Subdivision Comments

Date: 05/19/2023

RE: SP-23-00002- Mills-2

# MILLS SHORT PLAT PART OF SECTION 20, T. 18 N., R. 18 E., W.M. KITTITAS COUNTY, WASHINGTON

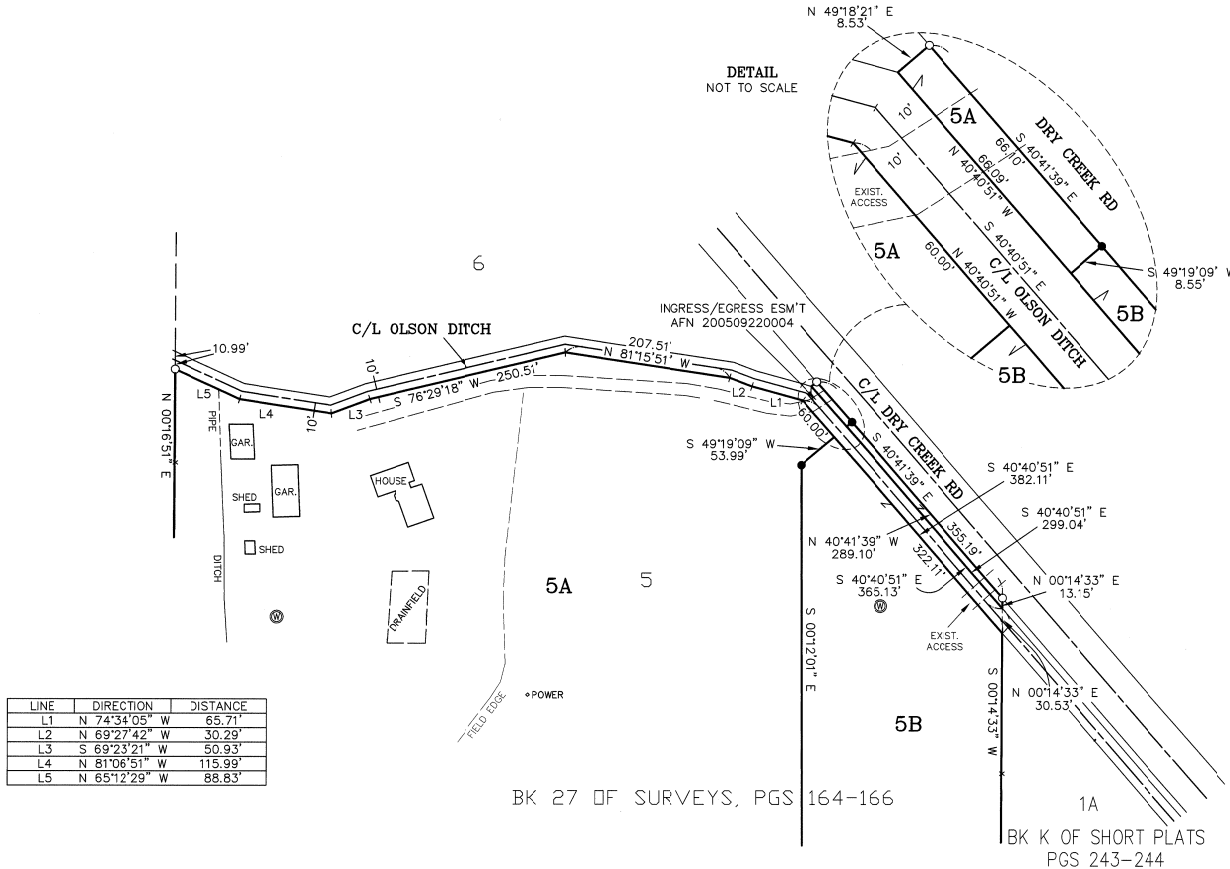
Proposed short plat indicates individual wells will be used. The wells must be drilled a minimum of 50 feet from any proposed property line. The applicant must prove physical availability of water for all new uses of water proposed lots of this project, which can be provided by (See Condition A-1) a well log or 4 hour draw down test as proof of water availability for each new well proposed. All persons who are making applications for land use including but not limited to short plats must comply with KCC Chapter 13.35.020.

A well site review with site plan is needed for each proposed lots. Along with a current water right for the proposed lots.

A-1 13.35.020(b) requires proof of adequate water supply, which can be submitted through a well log or 4 hour draw down test if an existing well is used and is older than 10 years. If shared wells are used, a signed, notarized, and recorded shared well=users agreement must be submitted. All individual and shared wells must meet the distance requirement of 50 feet from the property line, 50 feet from the septic tank and 100 feet from the drain field as per Kittitas County Critical Areas Ordinance 17A.08.25, and KCC Chapter 13.
